NORWICH TO TILBURY

EN020027

Comments on Submissions received at Deadline 1

Suffolk County Council [REDACTED]

Drawing Number: 10059280-ARC-EHR-ZZ-DR-ZZ-00432 Revision: B

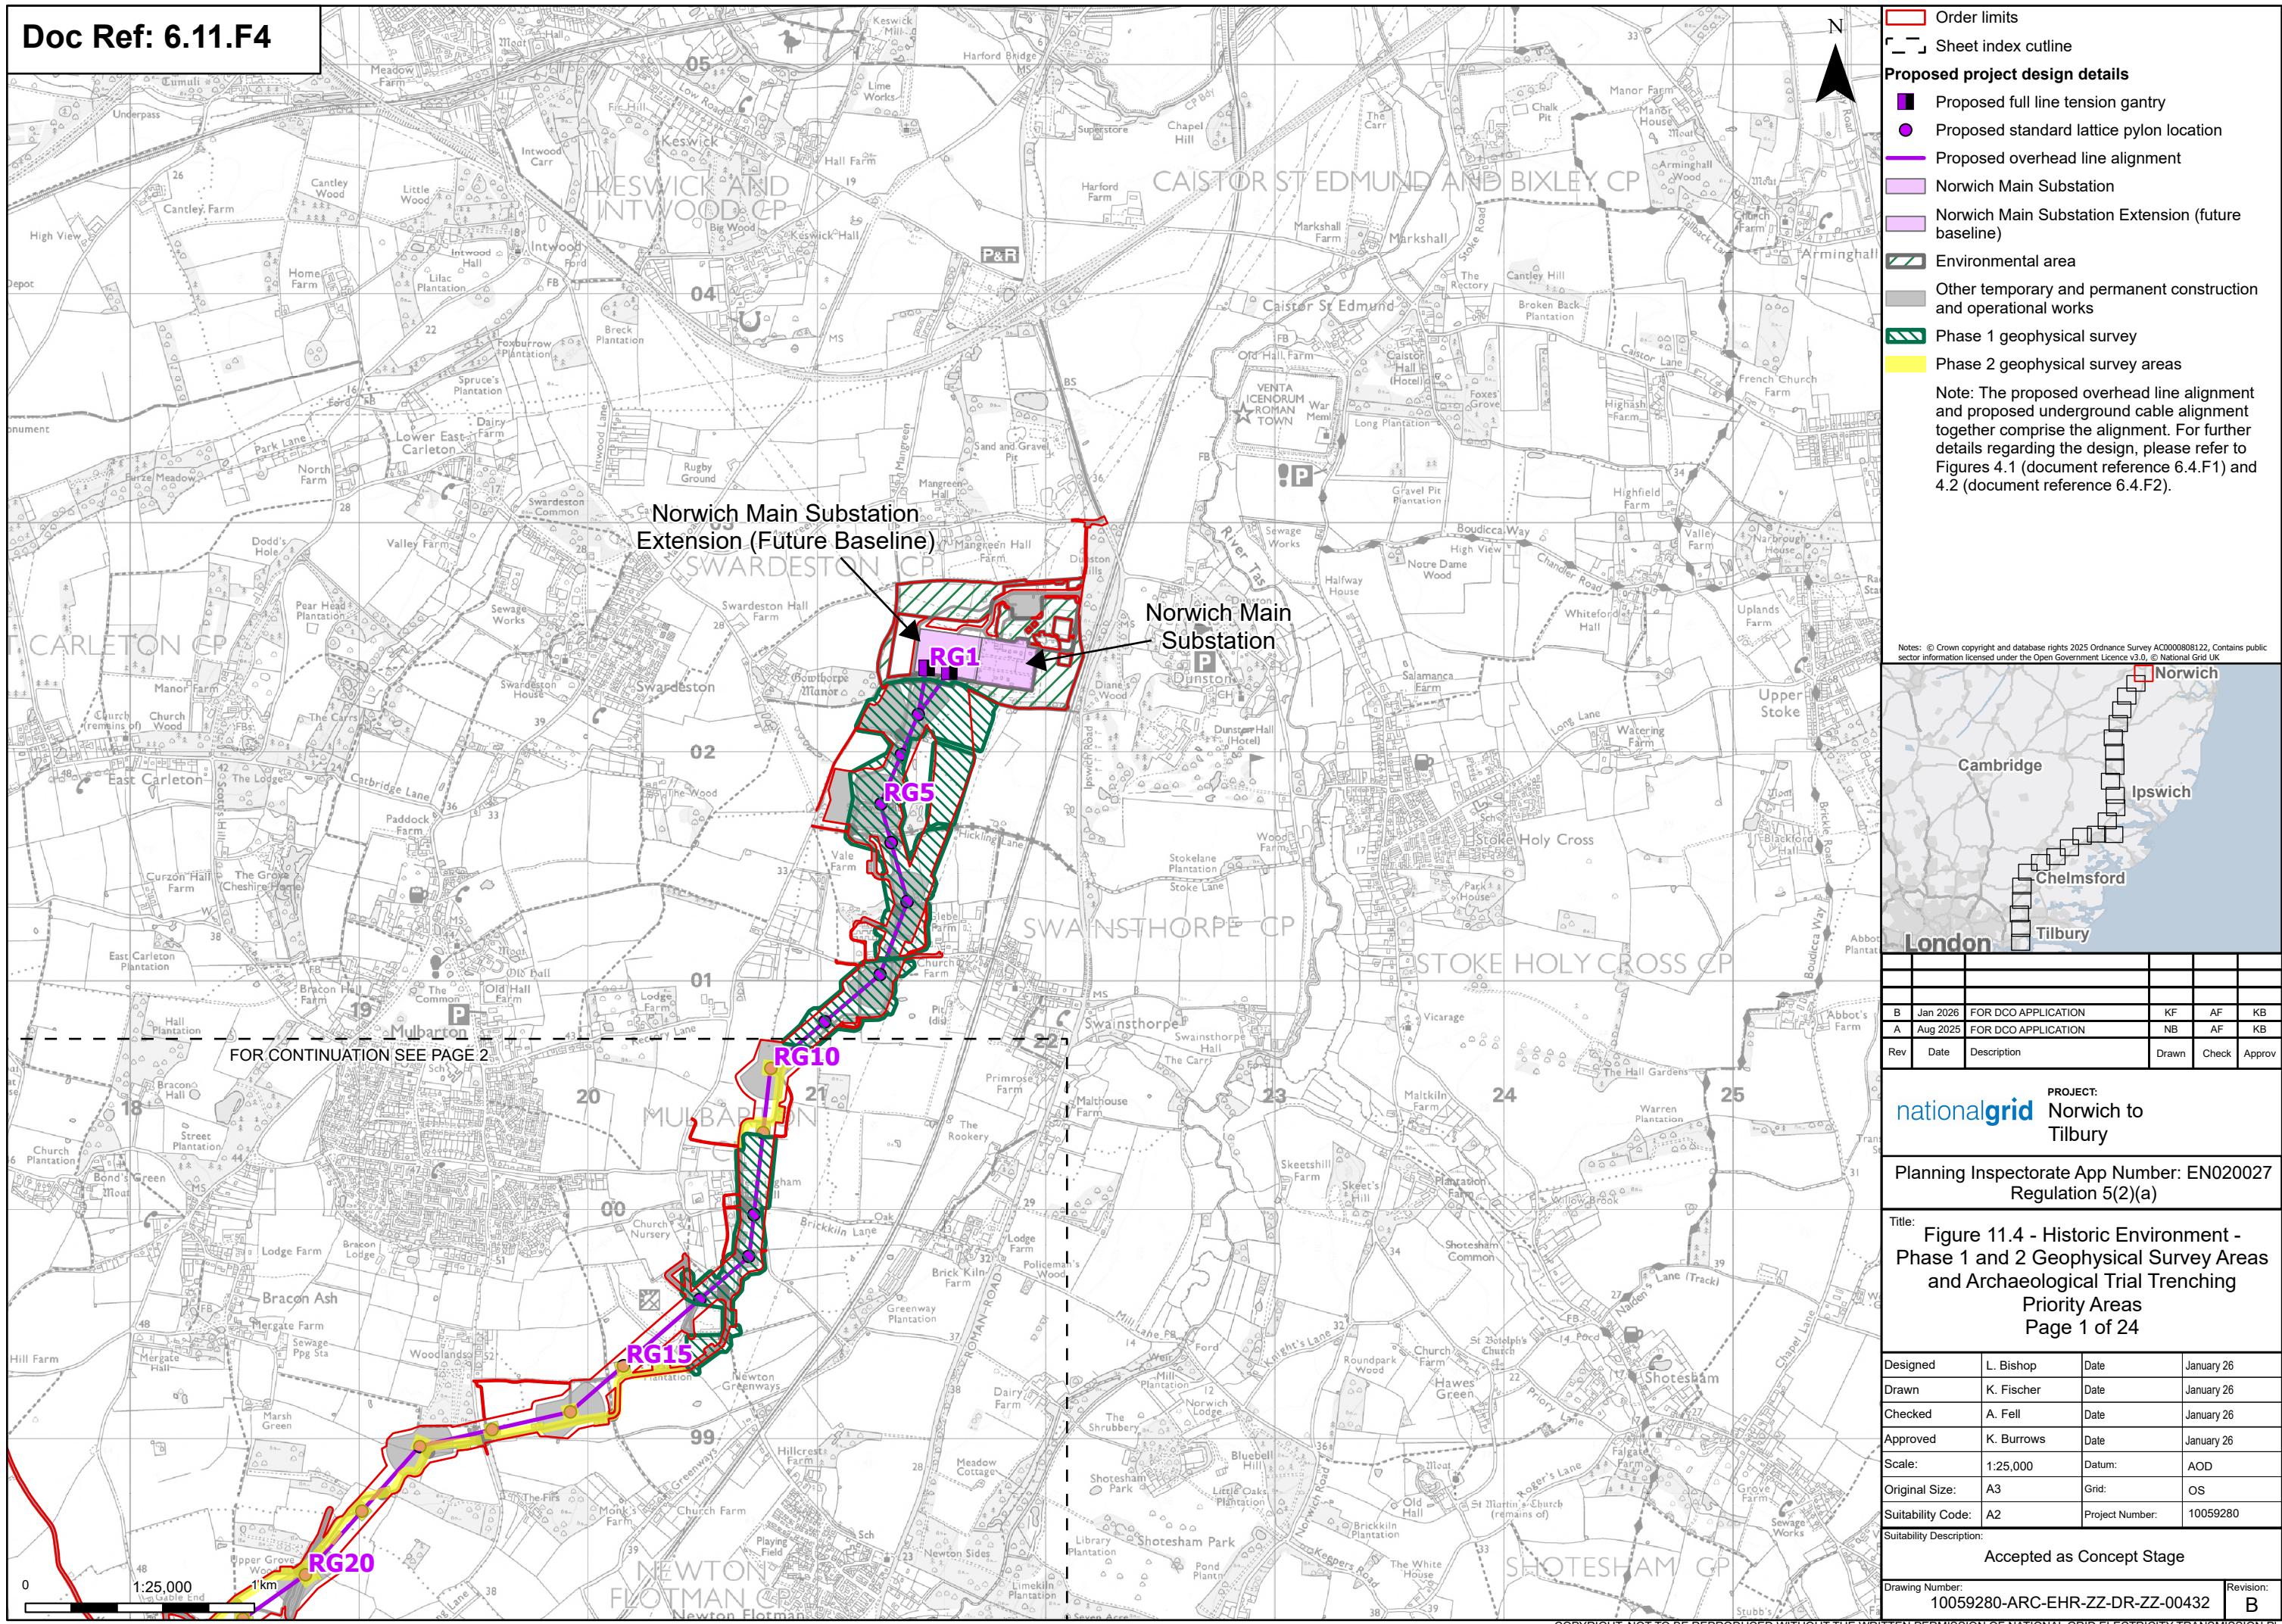
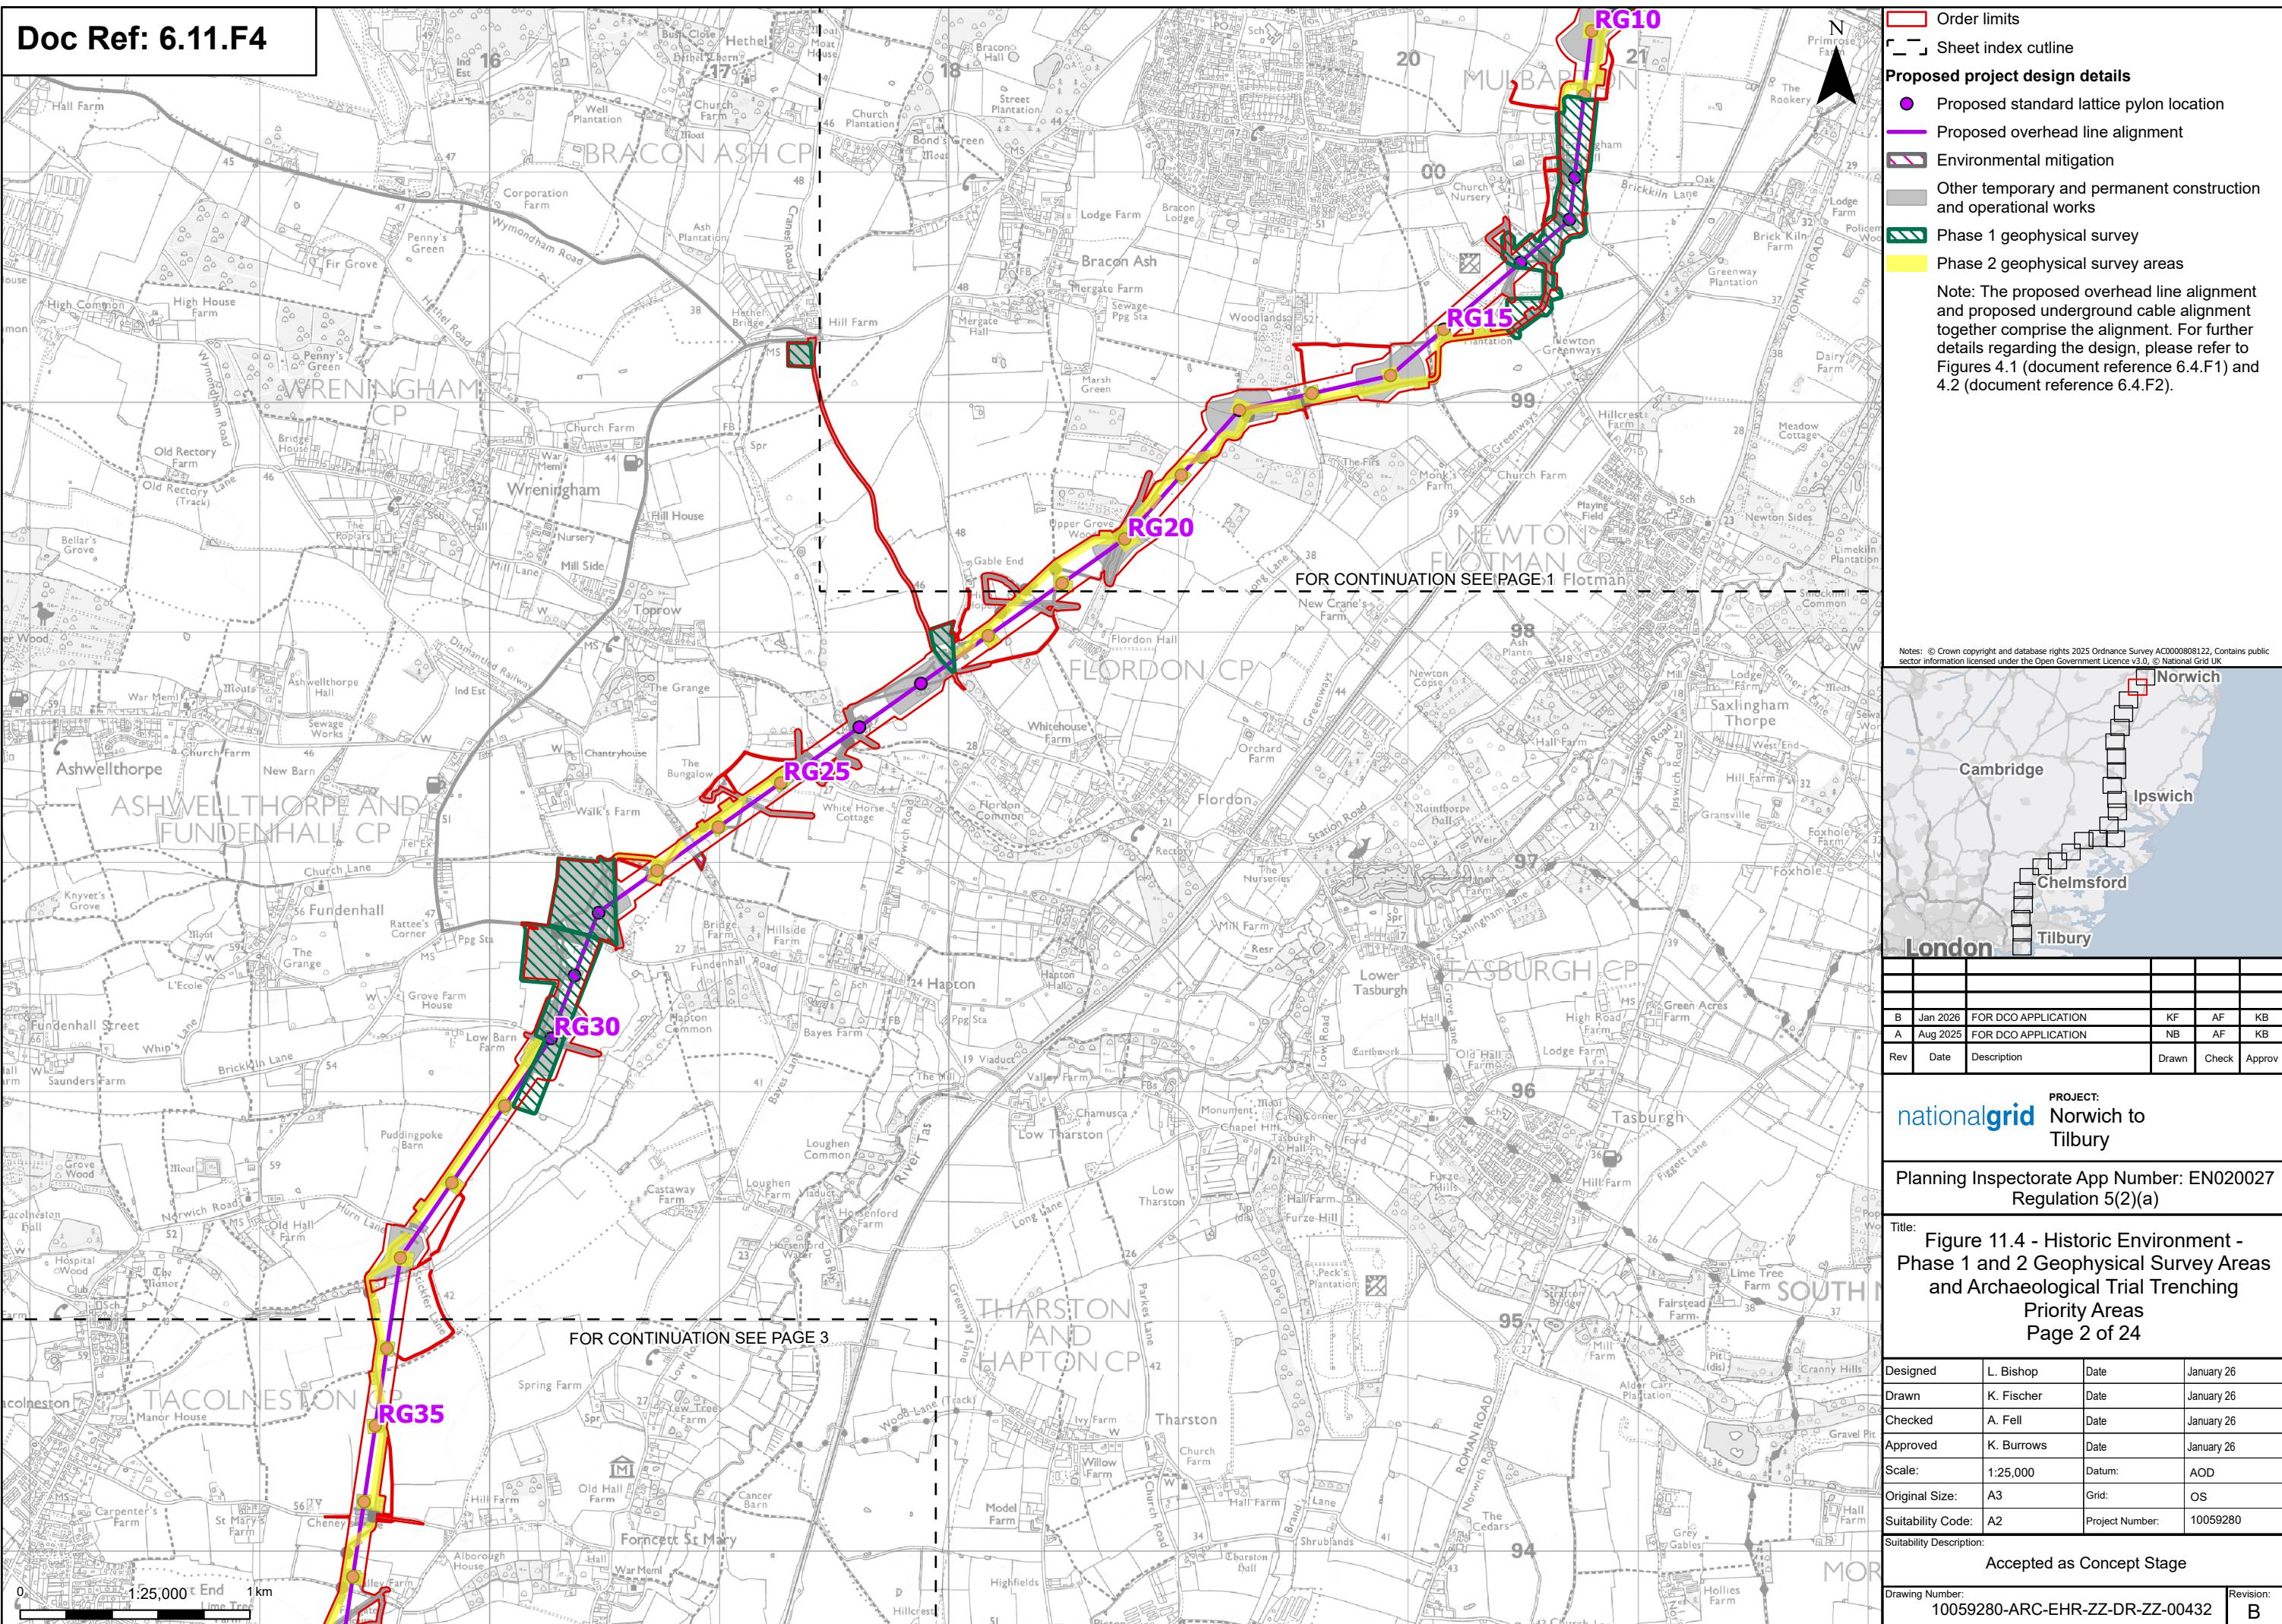
DCO requirement wording in Chapter 14 of the Joint Local Impact Report [REP1-178] .	
5.14	Historic Environment - Archaeology	<p>Table AB (24-25)</p> <p><i>“The Supplementary Environmental Information includes a Project-wide figure indicating the progress of the priority evaluation areas and Phase 2 geophysical survey (6.11.F4 Environmental Statement Figure 11.4 - Phase 1 and 2 Geophysical Survey Areas and Archaeological Trial Trenching Priority Areas [AS-082]). The Applicant proposes to update 7.5 Outline Archaeological Mitigation Strategy and Outline Written Scheme of Investigation [APP-328] during the examination phase in consultation with the Local Planning Authority Archaeological Advisors, which will include figures detailing the completed and planned evaluation.”</i></p>	<p>SCCAS notes this comment in relation to submitted figure 6.11.F4 Environmental Statement Figure 11.4 - Phase 1 and 2 Geophysical Survey Areas and Archaeological Trial Trenching Priority Areas [AS-082]</p>	[AS-082]

5.15	Historic Environment - Archaeology	<p>Table AB (26)</p> <p><i>“The Supplementary Environmental Information includes a Project-wide figure indicating the progress of the priority evaluation areas and Phase 2 geophysical survey (6.11.F4 Environmental Statement Figure 11.4 - Phase 1 and 2 Geophysical Survey Areas and Archaeological Trial Trenching</i></p>	<p>SCCAS reiterate that the Applicant must submit an amended 7.5 Outline Archaeological Mitigation Strategy and Outline Written Scheme of Investigation [APP-328] in reasonable time during the examination, incorporating LPA archaeological advisor comments. Allowing sufficient time for the LPA archaeological advisors and Historic England to comment on the document. The document must be approved by the</p>	[APP-328]

<p><i>Priority Areas [AS-082]). The Applicant proposes to update 7.5 Outline Archaeological Mitigation Strategy and Outline Written Scheme of Investigation [APP-328] during the examination phase in consultation with the Local Planning Authority Archaeological Advisors, which will include figures detailing the completed and planned evaluation.”</i></p>	<p>Local Authority Archaeological Advisors (Norfolk, Essex and Suffolk) and Historic England.</p> <p>If approval of the 7.5 Outline Archaeological Mitigation Strategy and Outline Written Scheme of Investigation [APP-328] cannot be achieved by the time of determination, the DCO must include provision for post-consent approval of the 7.5 Outline Archaeological Mitigation Strategy and Outline Written Scheme of Investigation [APP-328].</p>
